Your ref: MP 05_0129 MOD 3
Our ref: (0698/09DA & 0098/20DM)

20 April 2020

Response to Proposed Modification – Lakes Estate Residential Subdivision (MP 05_0129 MOD 3)

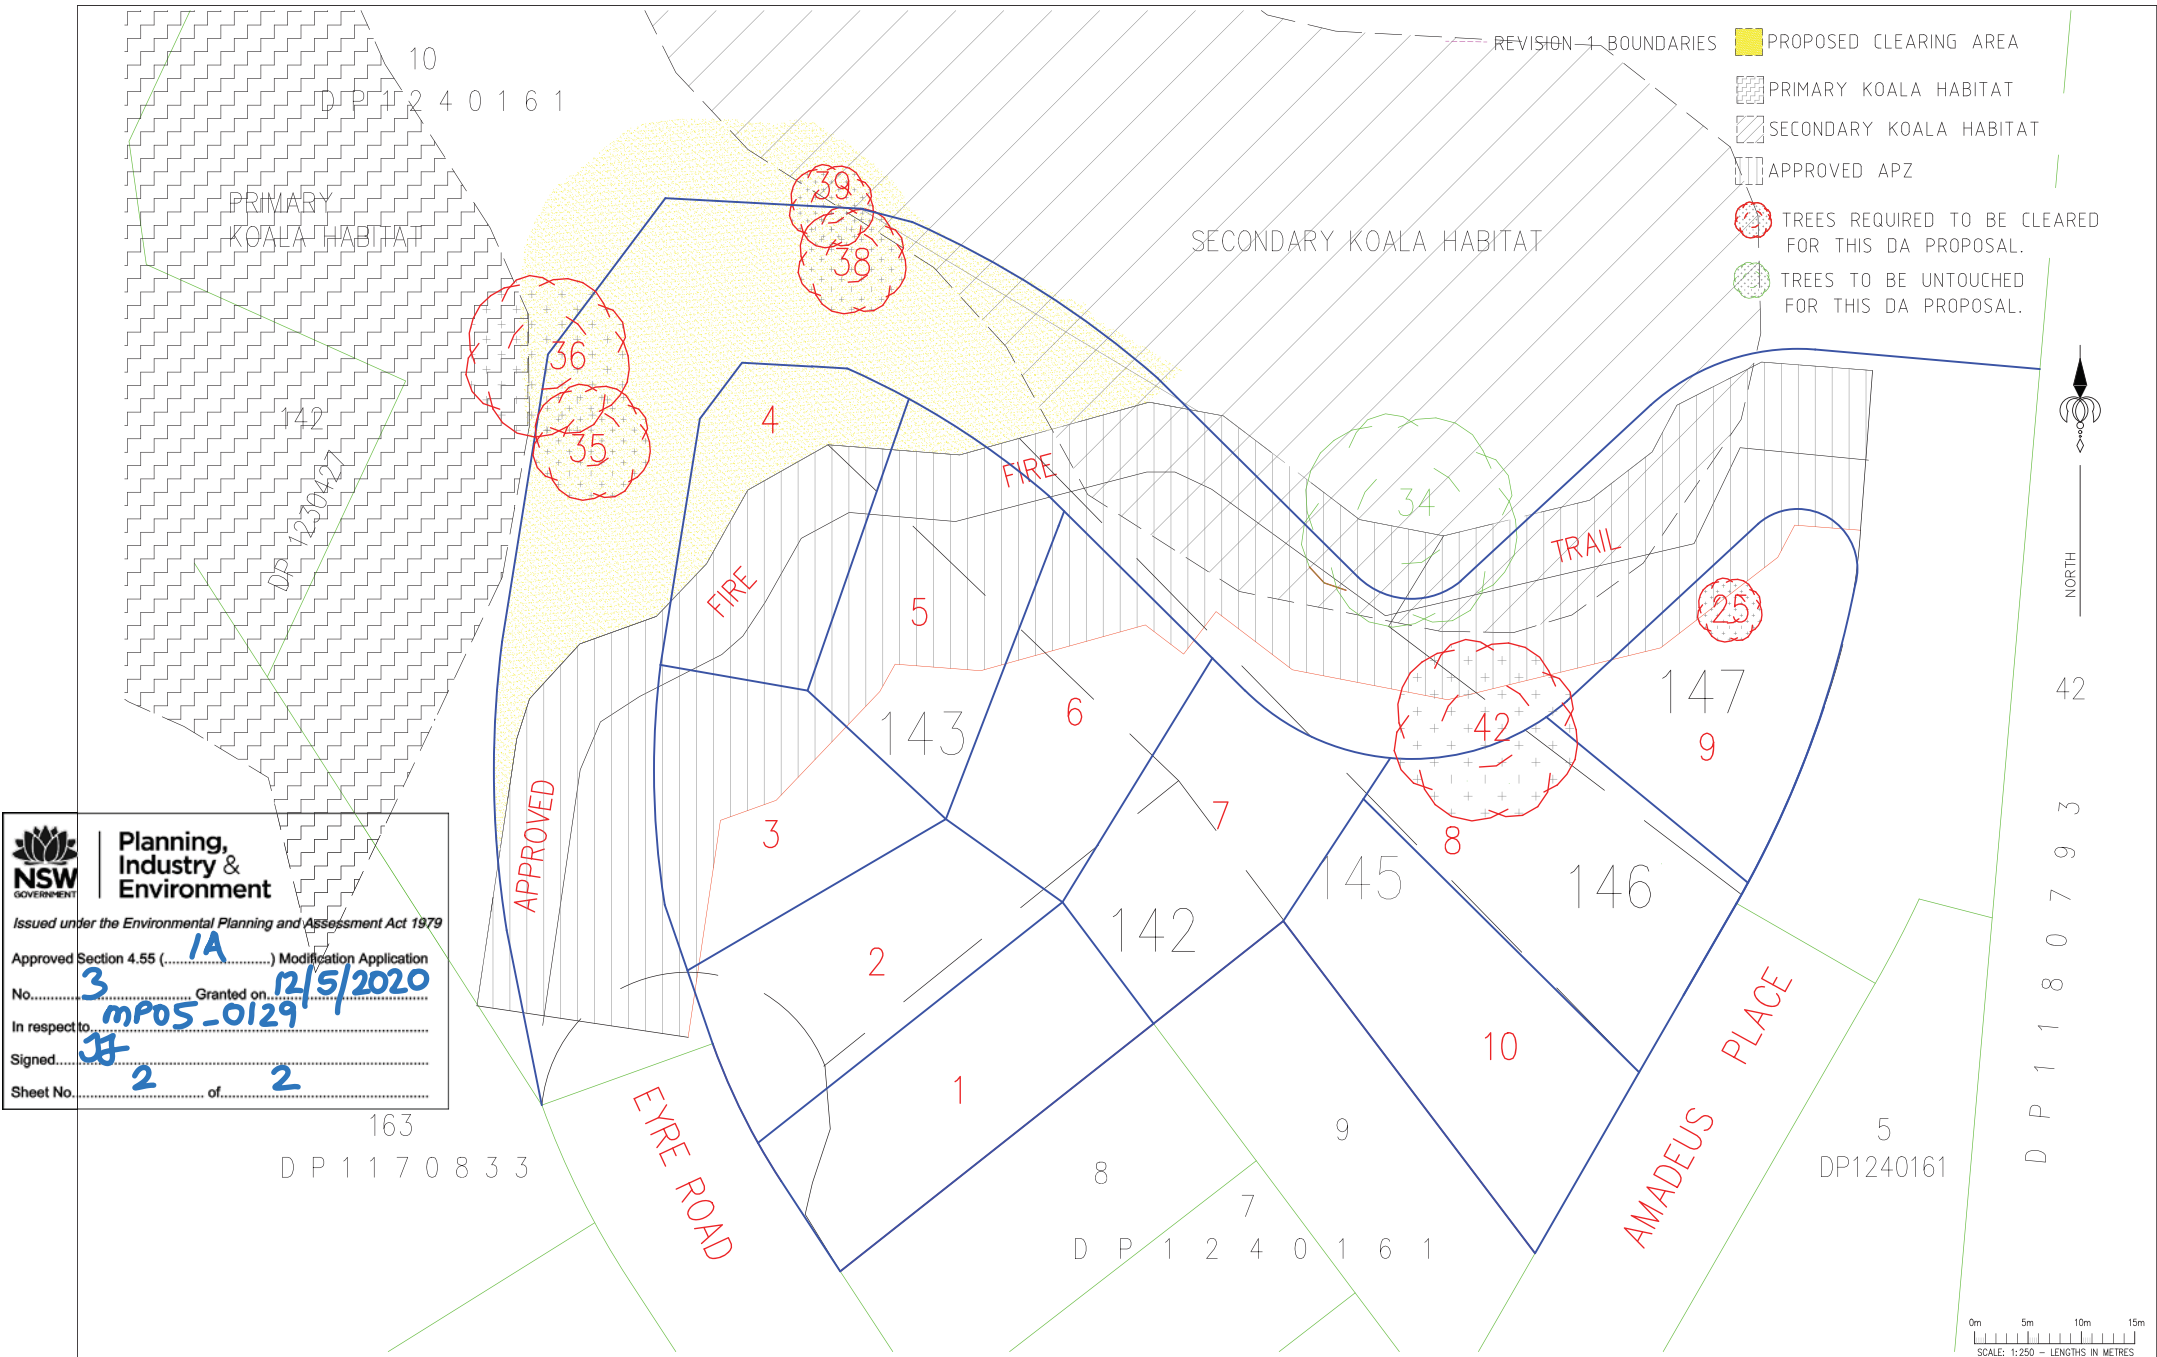
The current road design incorporates a verge of 3m, which is in contravention of the minimum Auspec requirement of 4m. If the Department were to support a reduced road width, Council recommends that the Department satisfy themselves that all services, including paths, trees, stormwater, sewer, electrical and telecommunications can be accommodated within the reduced verge.

The road design incorporates sections with a grade of up to 20% which exceeds the maximum recommended grade of 16% under Auspec. Road grades above 16% have implications for sight distances and pavement treatments. Council recommends that the design be amended to comply with the 16% maximum grade under Auspec to improve sight distances and to maintain consistency in pavement treatment.

The vertical curves between Ch140 and 245 on RS1 do not comply with Auspec requirements and consequently, the use of the forced sag is not supported due to its effect on riding comfort and sight distances.

It is not evident from the information provided that the proposed road design is suitably safe having regard to the speed/radius relationship. The horizontal curves appear way too tight. Councils Specifications identify for urban roads the minimum radius to be as per the table 2.2 (Auspec - Geometric Road Design) to suit the speed environment. Considerable evidence is required to demonstrate that the proposed design is safe, noting that the horizontal curves have tightened since the previous design was submitted. The horizontal speed environment needs to match the vertical speed environment.

Additional space will need to be provided in the verge for barriers if clear zones cannot be provided in accordance with Austroads – Guide to Road Design - Part 6. Verge slopes within road reserves and reserves need to comply with Council standards (max 1:4 fill, 1:3 cut). The 1:2 verge slope in this location is not supported.

The extension of Amadeus Place will need to be 8m wide to comply with Planning for Bushfire Protection 2019 as it adjoins a vegetated reserve (the current section does not adjoin reserve – it adjoins private property).
